East Anglia ONE North and East Anglia TWO Offshore Windfarms

Applicants' Comments on Natural England's Deadline 4 Submissions

Applicant: East Anglia TWO and East Anglia ONE North Limited
Document Reference: ExA.AS-3.D5.V1
SPR Reference: EA1N_EA2-DWF-ENV-REP-IBR-001218

Date: 3rd February 2021
Revision: Version 1
Author: Royal HaskoningDHV

**Figure 6 Modelled distribution of red throated divers for years preceding windfarm construction. This is purely in order to provide interpretable numbers for the colour scale used in the maps and should not be seen as an accurate estimation of absolute population densities**

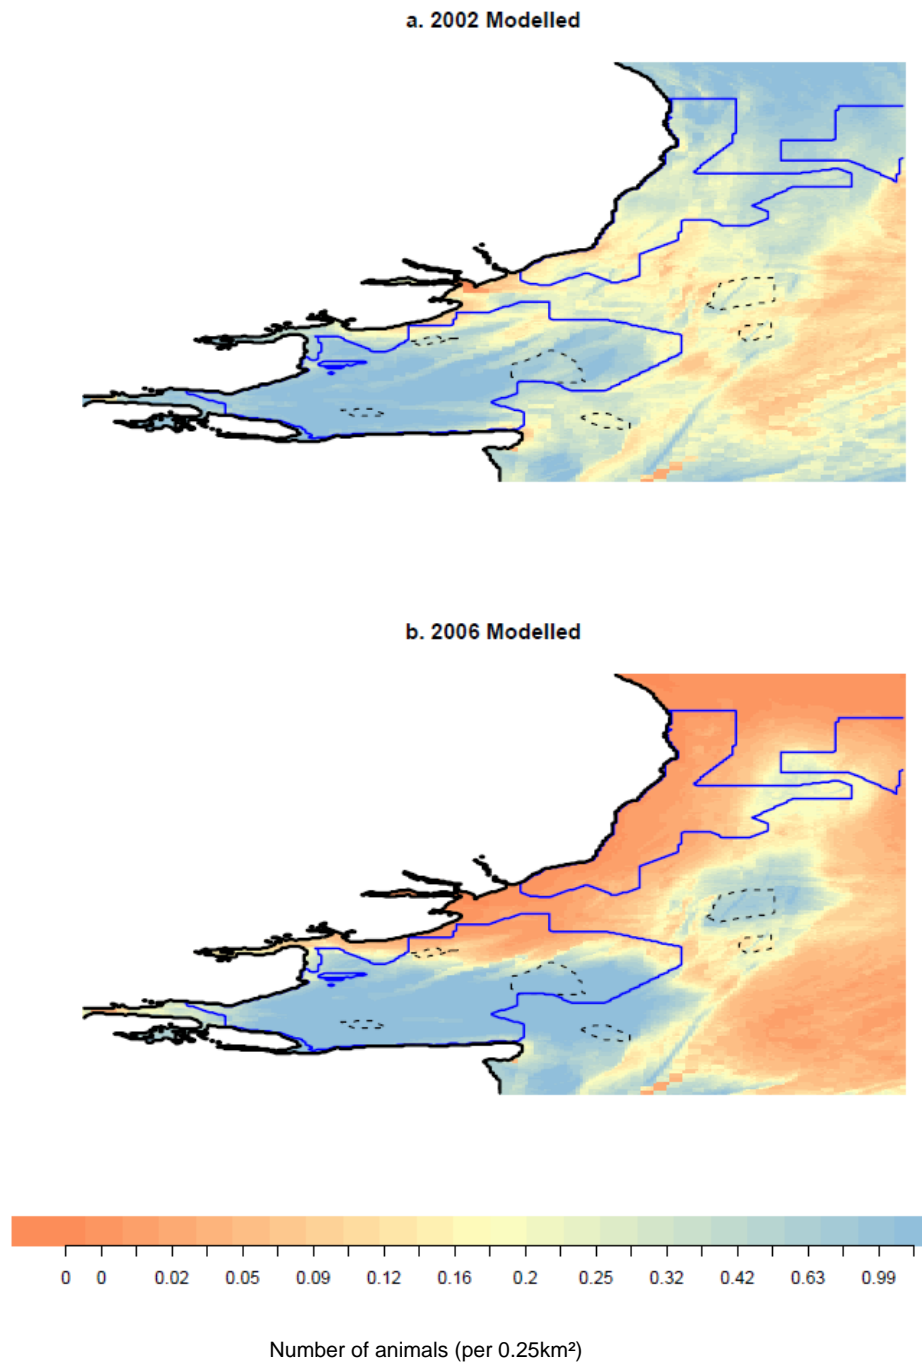
015	We note that the relative diver distributions in Appendix 1 figure 6a and 8a are very similar. The remarkably similar distributions between factualls and counterfactuals (Appendix 1 figures 7 and 8) are likely due to the fact that the covariates used are mostly static, and if distance to windfarm is not strongly influencing predictions, removing it or changing it as a parameter should not greatly impact predictive output. Counterfactuals were created here to act as a baseline for which to compare model predictions. This was done by simply changing the distance to windfarm parameter to represent the	The Applicants have interpreted the spatiotemporal term in the selected model to include missing covariates or intrinsically driven species aggregations, but no direct effects of windfarms. This carries the implicit assumption that there are no residual effects of distance to windfarms that are not captured by the distance-to-windfarm term itself. We base this on the fact that distance to windfarms is known with high accuracy and the time points at which different windfarms are introduced to the system are also precisely known. Most importantly, the distance to windfarm term is modelled
